KITTITAS COUNTY COMMUNITY DEVELOPMENT SERVICES

January 17, 2025

RE: SD-24-00003 WDFW Matoon – Request for Additional Information

MATTOON LAKE ACCESS
 ACCESS REDEVELOPMENT
 ENLARGED PROPOSED SITE PLAN

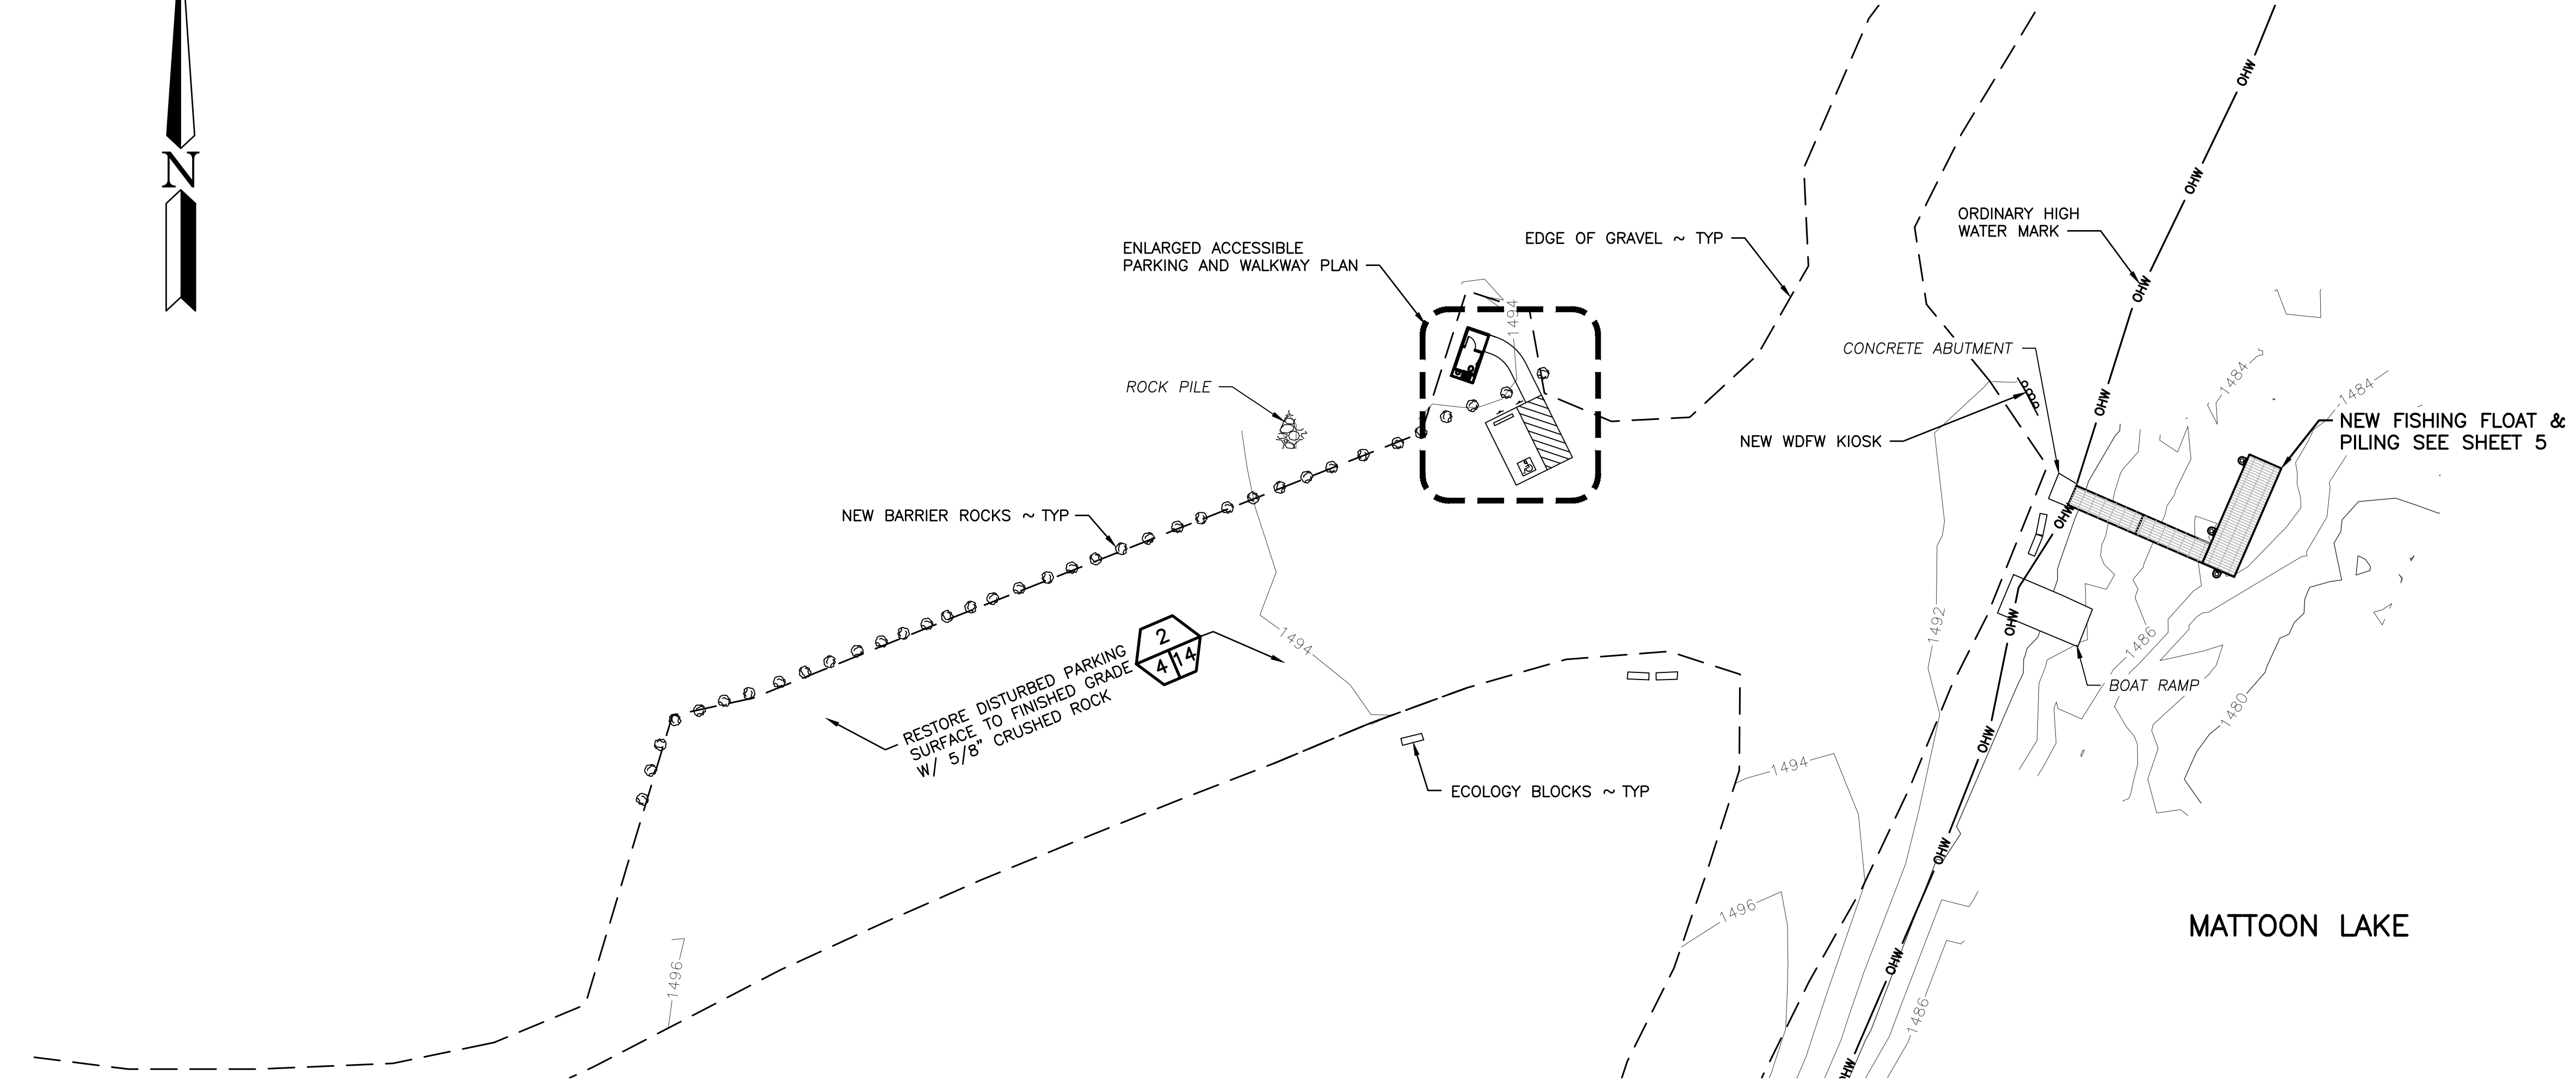
- 1) Per KCC 17B.07.070(2)(a) & 15A.03, a site plan showing the location and dimensions of the development is required. Please show the dimensions and location of the parking lot, rock barrier, kiosk, vault toilet and boarded float. Please add the edge of shoreline and the wetland to the south of the proposed development. An updated/revised site plan showing these items is required.
- a) The current site plan does not show the dimensions and locations of parts of the proposed development.
